DECISION DELEGATED TO HEAD OF PLANNING

Application No: H03-1246-21 **Applicant:** Poplar Farm Estates Ltd

Proposal: Residential development comprising 8 dwellings & private drive - approved under H03-1153-18. Modification of Condition 2 to allow amendments to previously approved plans

Location: The Former Plough Main Road Deeping St Nicholas

Proposed Side Elevation
PLOTS 1 & 2, 7 & 8

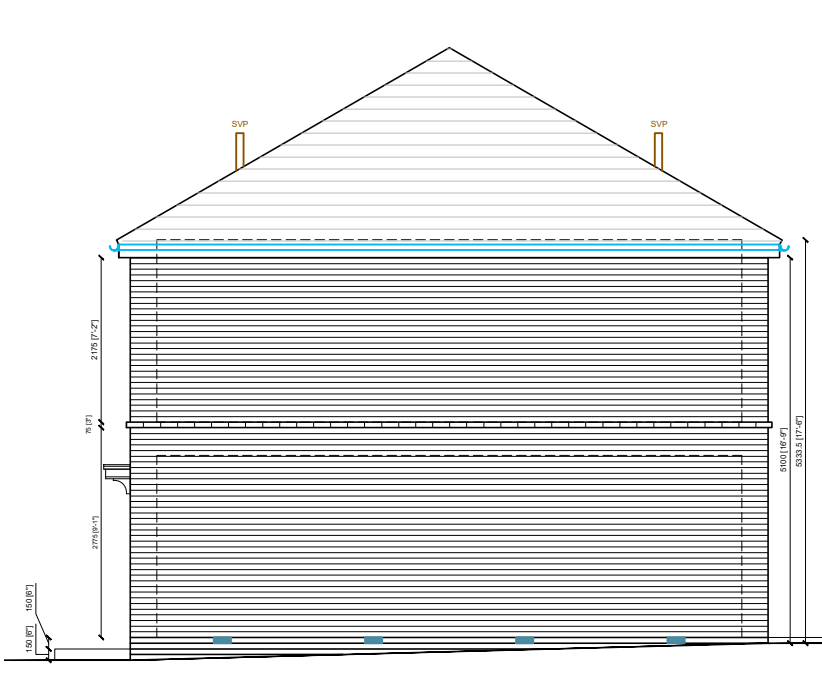
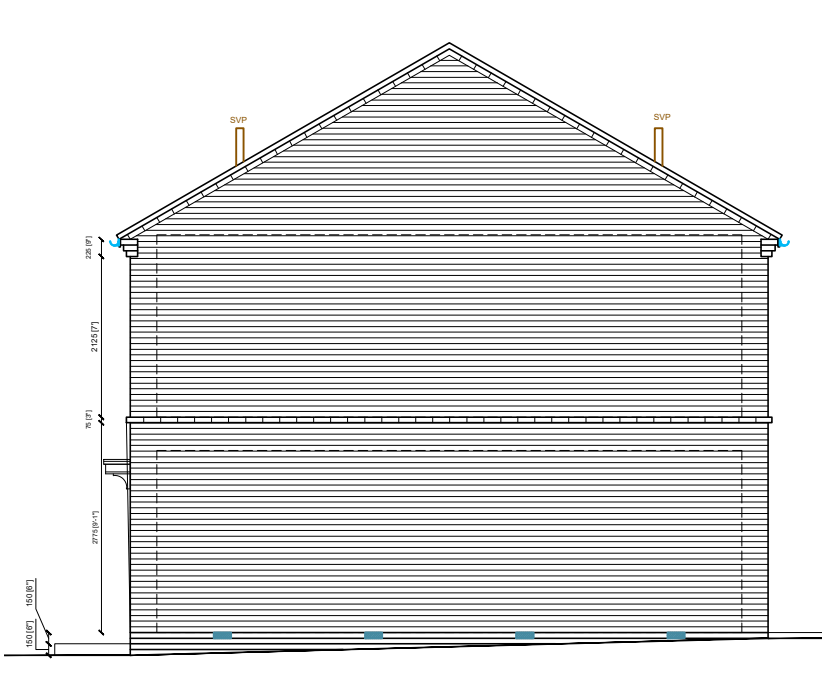
2. The external design of the buildings has only been altered in minor way via the removal of the side elevation first window in the previous proposal. The orientation of the buildings has not been altered, and the properties benefit from south facing back gardens to maximise natural sunlight during the day. The installation of air source heat pumps to the rear of the buildings will help reduce finite fuel reliance, and at a size of 0.97 metres wide and 0.82 metres in height they are not considered to impact the overall built design of the properties.

There is not considered to be a material overshadowing or overbearing aspect from the proposals. The blank side elevation wall of plots 5/6 is approximately 9 metres away from the rear elevation wall of 2 Plough Row to the west. This is not considered to lead to a material loss of light throughout the day when light calculations are made. The blank side elevation wall wall of plots 7/8 is approximately 20 metres away from the rear elevation wall of 6 Plough Row to the west. This is also not considered to lead to a material loss of light throughout the day when light calculations are made. The blank side elevation wall of plots 1/2 is approximately 7 metres away from a property named Kaleda to the east. This is not considered to lead to a material loss of light throughout the day when light calculations are made. The blank side elevation wall of plots 3/4 is approximately 20 metres away from a property named Kaleda to the east. This is also not considered to lead to a

Proposed Site Plan/Roof Plan
PLOTS 1 to 8

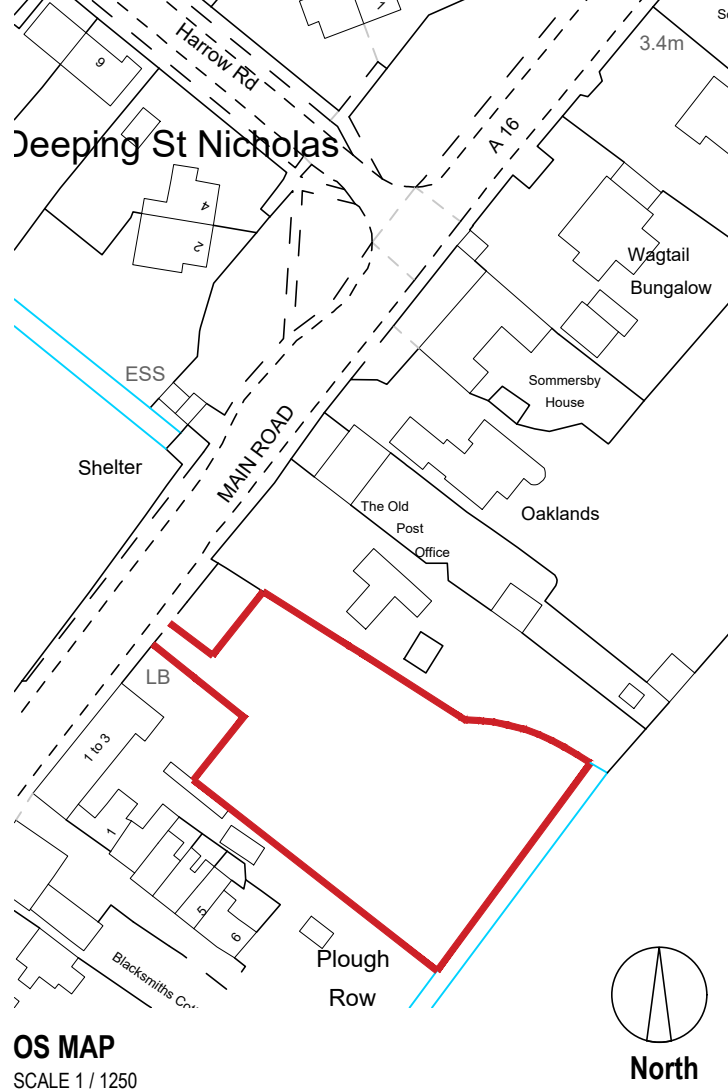
Proximity to existing hedge.

The footprint of the buildings has moved - This is incorrect. The distance to boundaries have been measured compared to those of the H03-1153-18 block plan. The distance to boundaries have not changed, nor has the footprint of the dwellings.

Drainage to a dyke at the rear of the site - This is incorrect. Drainage will be via infiltration.
